October 5, 2023

RE: Solberg Gravel Pit
Application for Special Use Permit for Minerals Extraction

Figure 4: Site Plan

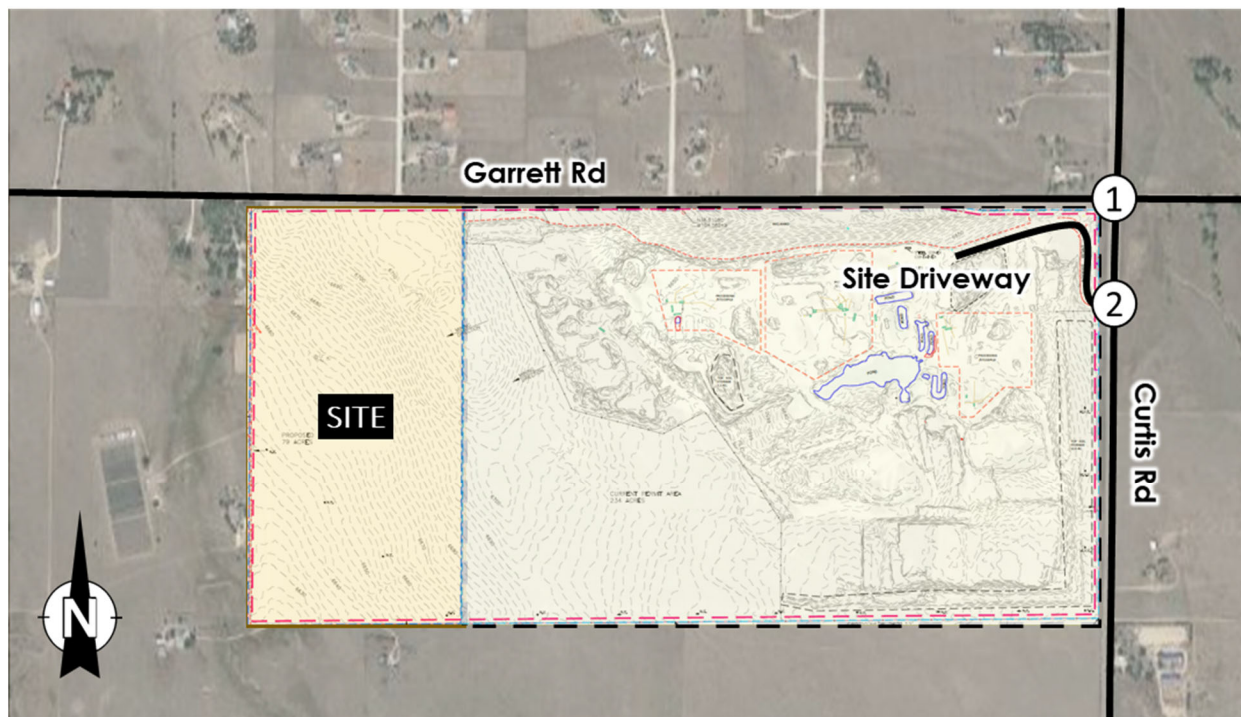
Review 1 comment: Please identify what the required Haul Route is for the haul vehicles.
Review 2: Unresolved. Please indicate the required haul route (north on Curtis, & westward on Garret?) for the haul vehicles.
